Development Control
Ribble Valley Borough Council

Your ref: 23/0165
Our ref: 23/0165HDC/RH
Date: 04/05/2023

Location: Land at Neddy Lane, Billington
Proposal: Proposed temporary construction access and haul route and associated works and will be used specifically for construction of the flood compensation scheme.

Development	BILLINGTON		
Location	NEDDY LANE		
Marketing Name	CALDER GRANGE		
Drawing Title	Hall Road Layout		
Drawing Number	4441 / Eng / 440-1	Revision	-
Drawn By	CLB	Scale @ A1	1:500
Checked by	-	First Issue	09.02.23

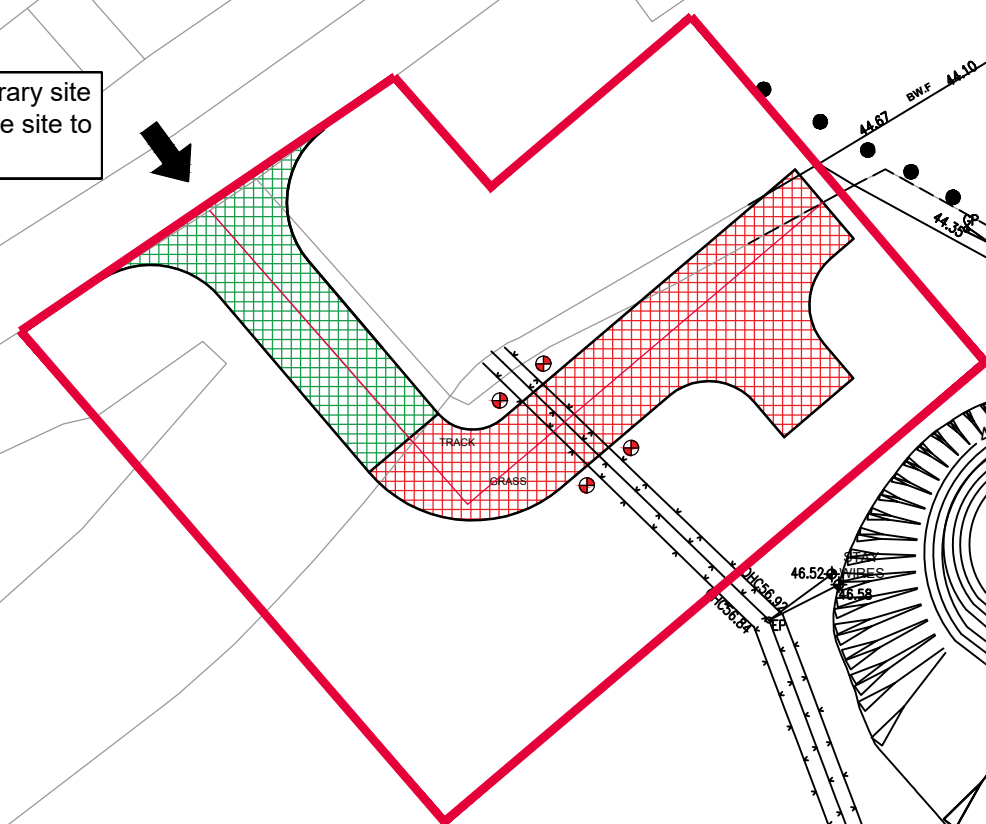
An existing lay-by is located on the A59 just to the North East of the proposed site access. Lancashire County Council Highways request that it is temporarily closed as part of the traffic management arrangements. To avoid unnecessary potential conflict.
